Re: **68 Brighton Road, Rathgar, Dublin 6.**
Your Ref: **ABP-306105-19**
Plan Ref: **0488/19**

APPEAL COMMENTS

EXPP: 0488/19 (Section 5 Declaration Application)

PROPOSAL: EXPP: Protected Structure:
Replacement of rooflight.

**ROOF LIGHT
 DETAILS**

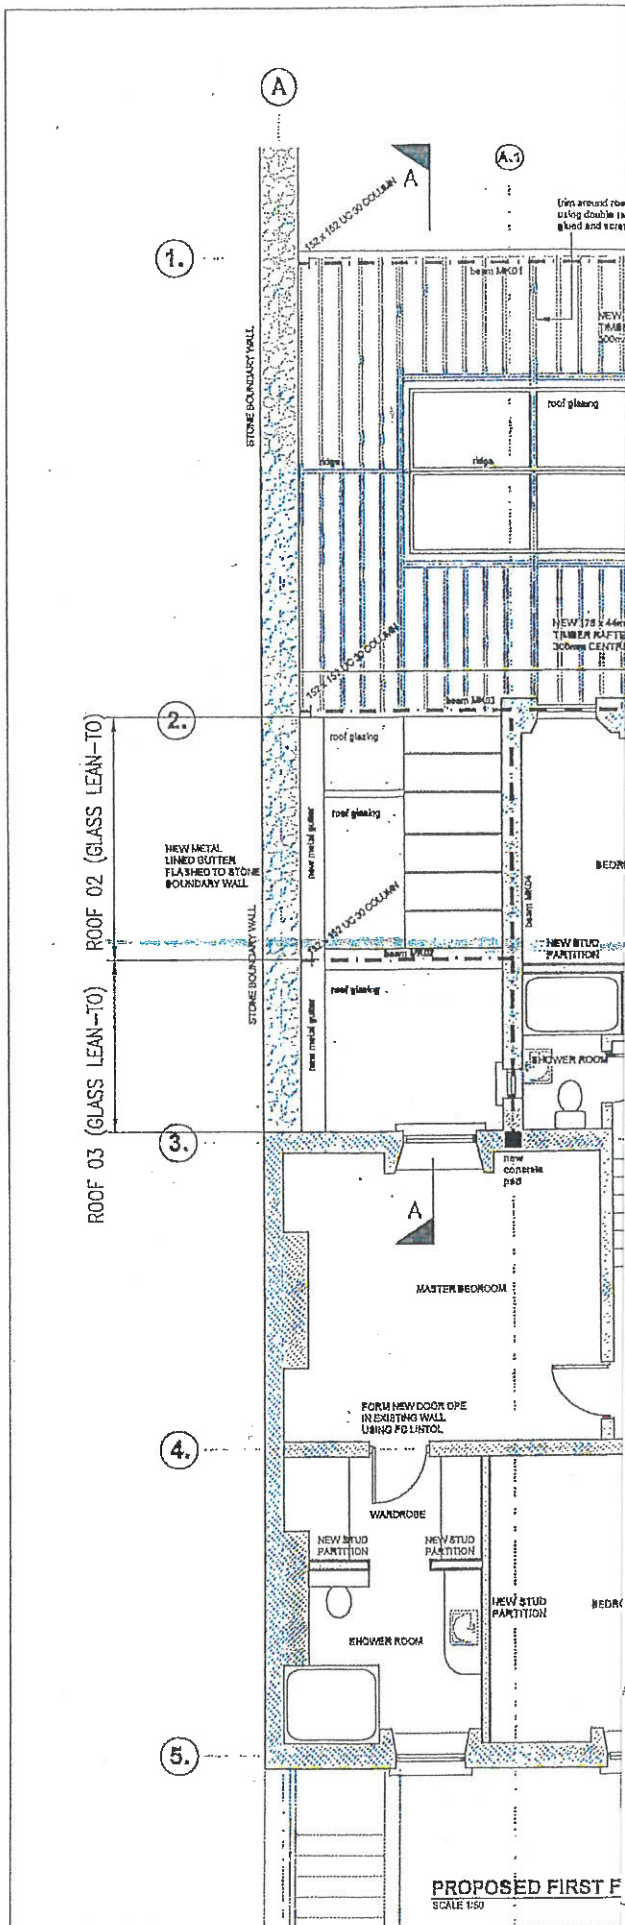
Architectural Heritage Protection Guidelines for Planning Authorities (2011). In this instance, the subject Section 5 Declaration application, the installation of a rooflight in the front slope of the roof, was considered and assessed and the works were not considered exempted development having regard to those statutory Guidelines and Sections 4(1)(h) and 57 of the Act. Insufficient evidence, in the form of old photographs or drawings, has been provided to indicate that the historic rooflight stored on site came from the front slope of the roof.

Accordingly, the Architectural Heritage Protection Guidelines for Planning Authorities (2011), along with best conservation practice, supports the opinion of the Planning Authority that the insertion of a rooflight into the principal, front slope would comprise a material alteration to the protected structure.

The Planning Authority is of the opinion that the rooflight to 68 Brighton Road, which is the subject to this appeal, would materially affect the character of the protected structure and therefore, would comprise works/development which would not be exempted development under Sections 4(1)(h) and 57 of the Act.
